Our ref: DOC20/419320

Senders ref: SSI 9973 MOD 1

Subject: Eastern Gas Pipeline – Modification 1 – Port Kembla Lateral Modification

Senior Team Leader, Planning (Illawarra)
Biodiversity & Conservation Division
Environment, Energy and Science

client: JEMENA		
project: MODIFICATION REPORT PORT KEMBLA LATERAL LOOPING PROJECT		
title: NATIVE VEGETATION		
project no: MELEN269488-R03	figure no: FIGURE 12	rev: A

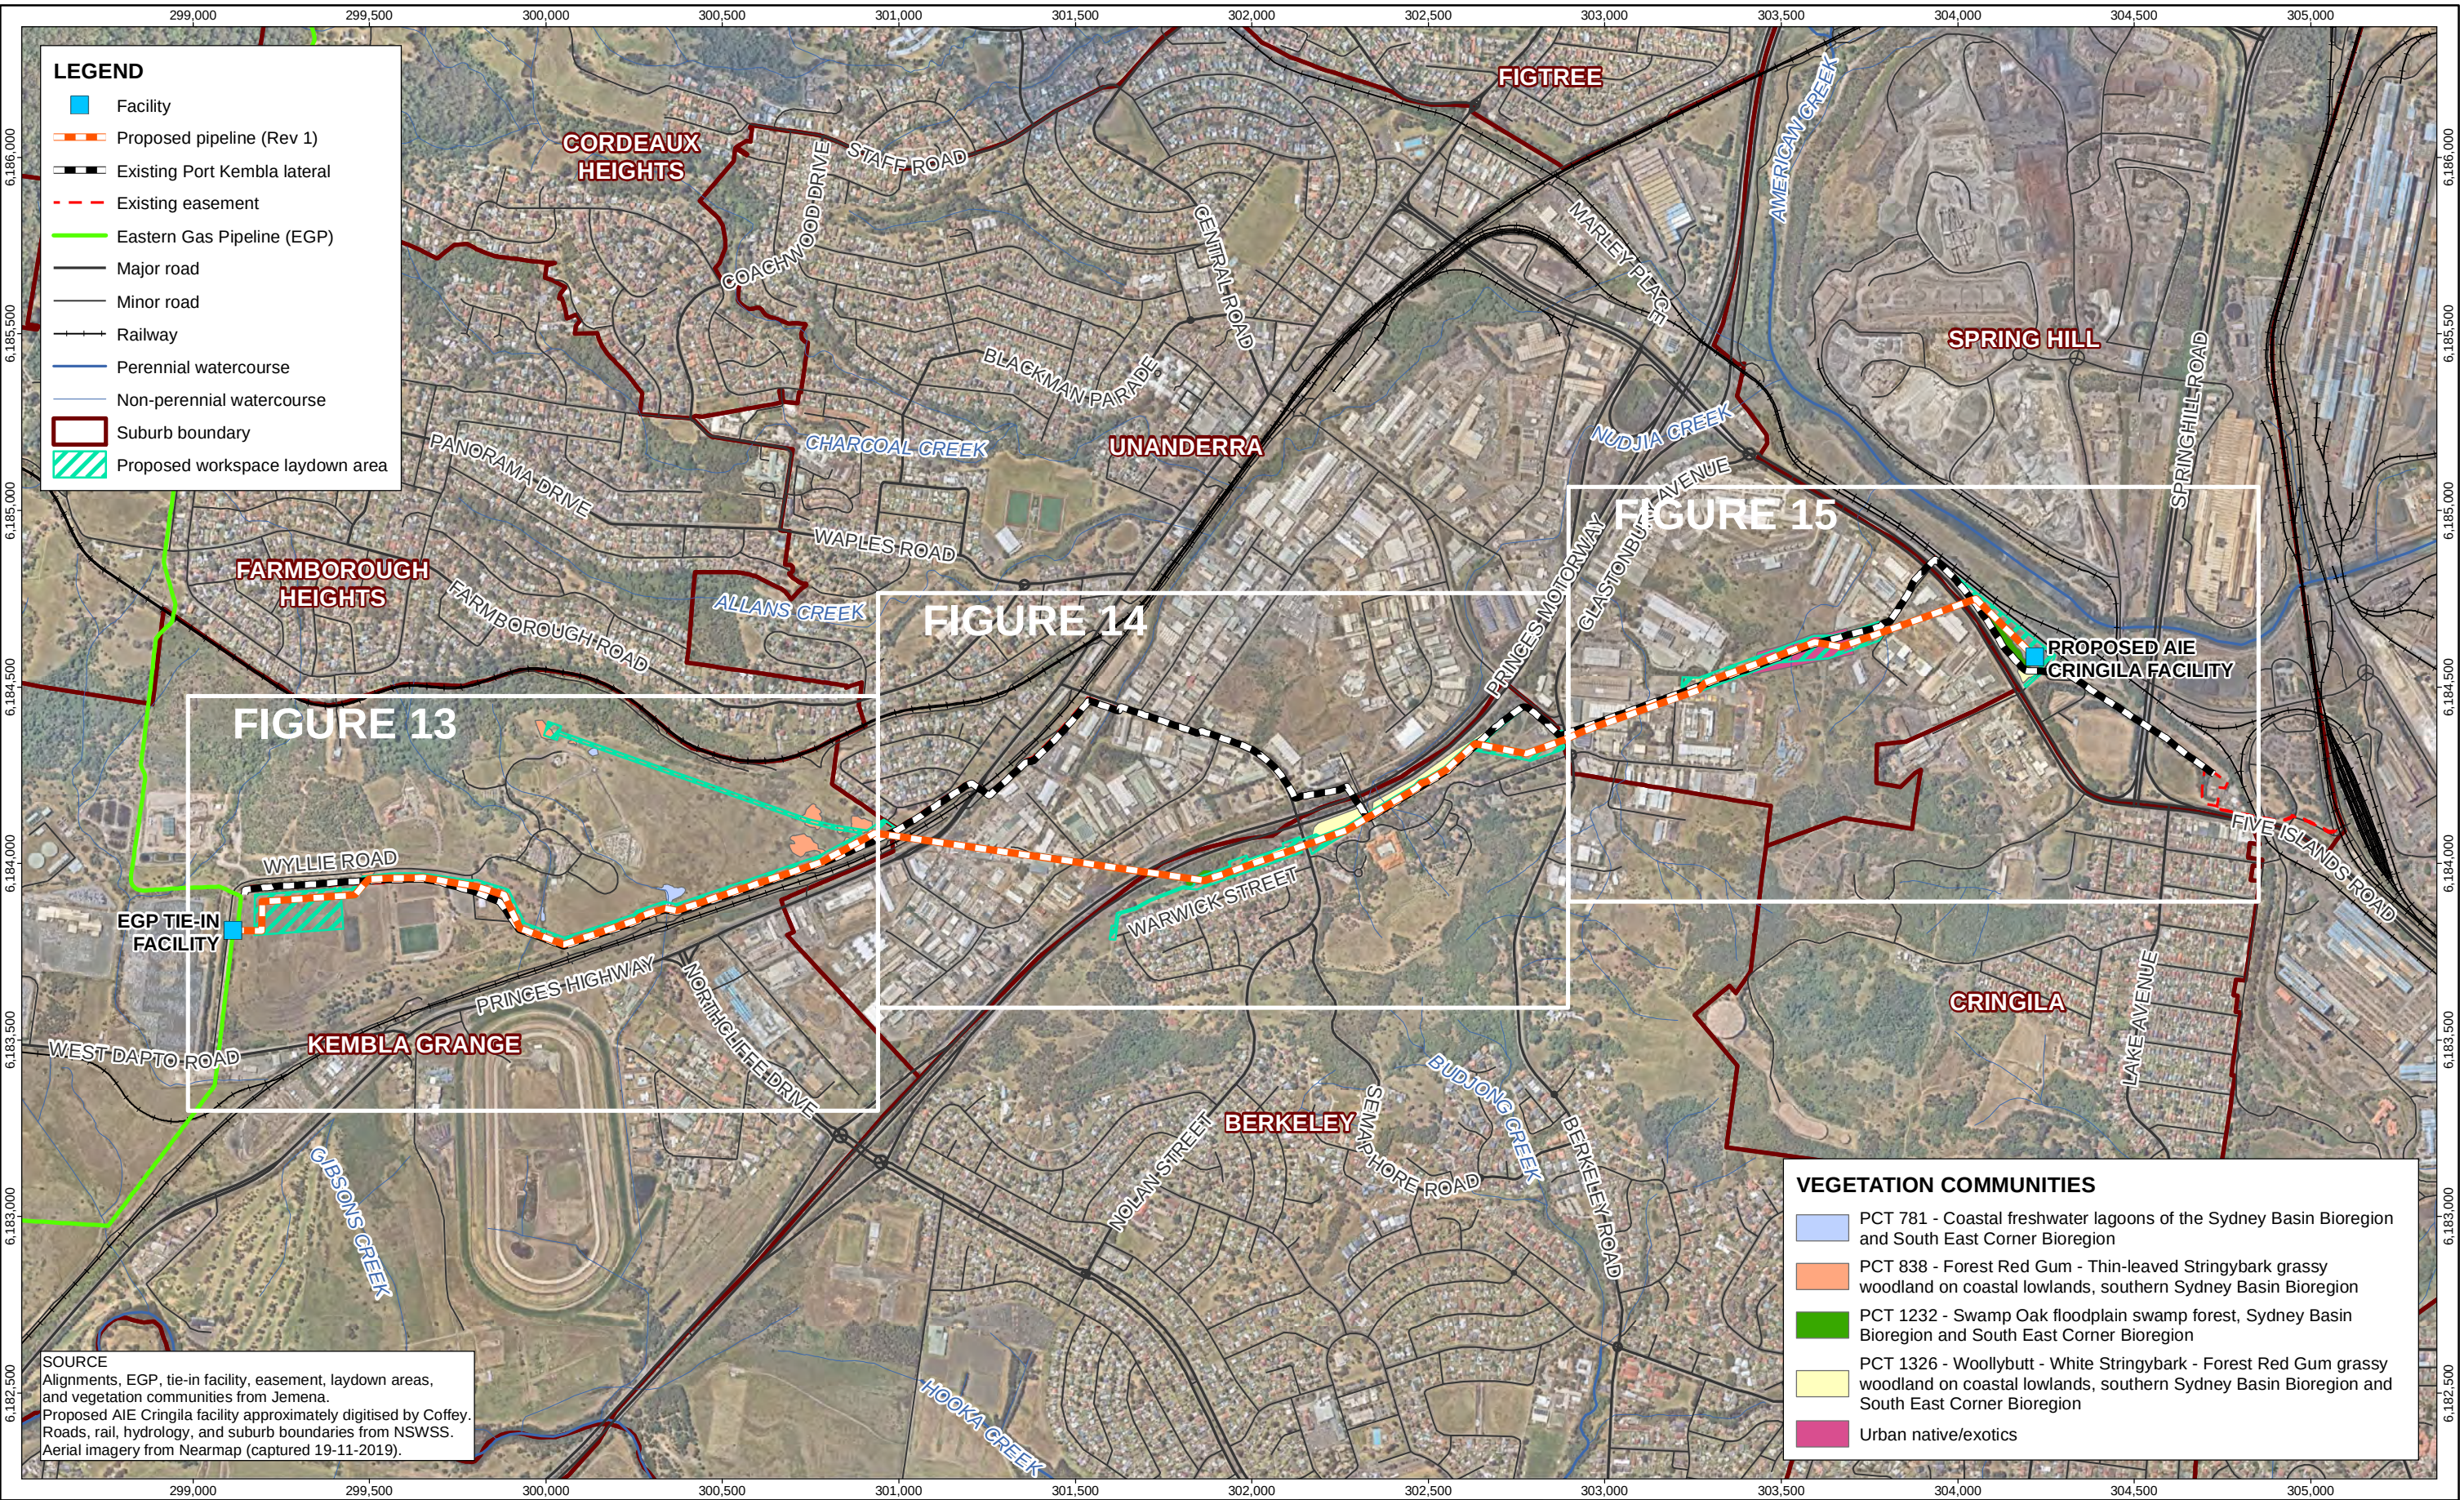
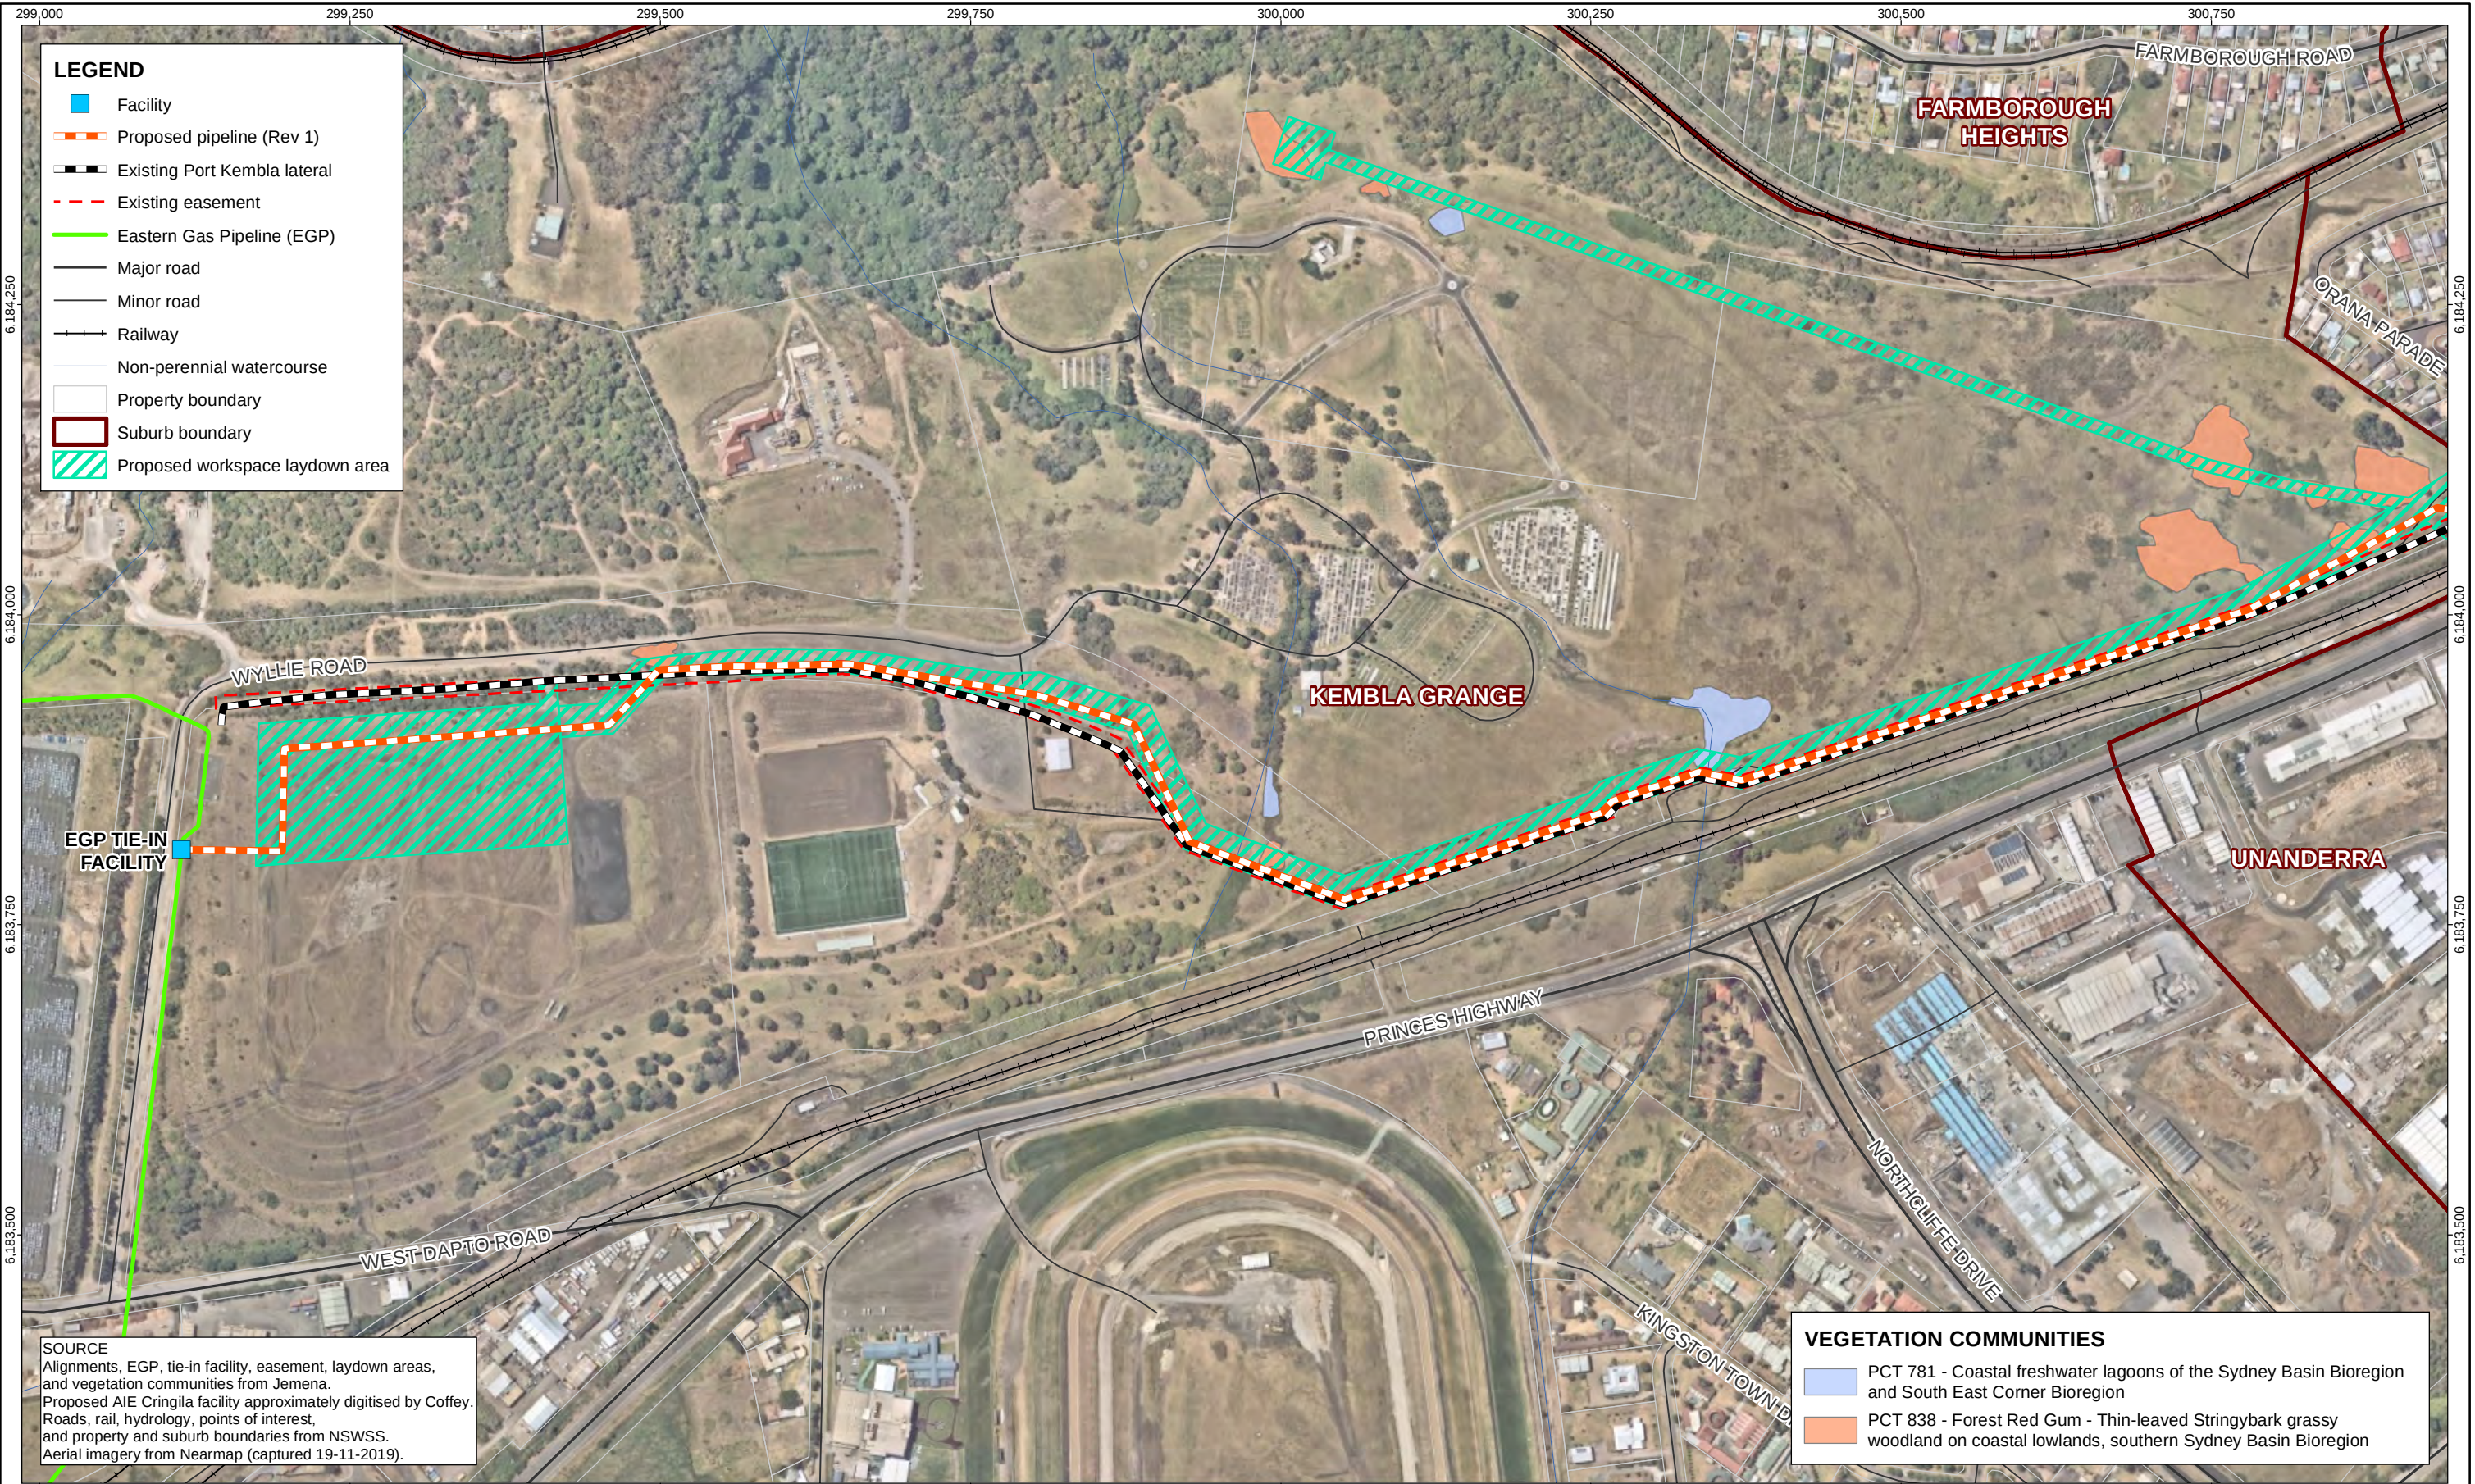
We have reviewed the Biodiversity Development Assessment Report (BDAR) and raise no objections to the findings. We note that the consultant has allocated some regrowth vegetation to the plant community type (PCT) 838, associated with the Illawarra Lowlands Grassy Woodland threatened ecological community (TEC), and a small drainage swale to PCT 781, associated with the Freshwater Wetlands on Coastal Floodplains TEC.

Impacts to both of the communities are minor and are proposed to be offset through the retirement of credits. Should the modification be approved, we recommend that appropriate conditions of consent be recommended requiring the retirement of the requisite credits. We remain available to assist with drafting of conditions of consent upon request.
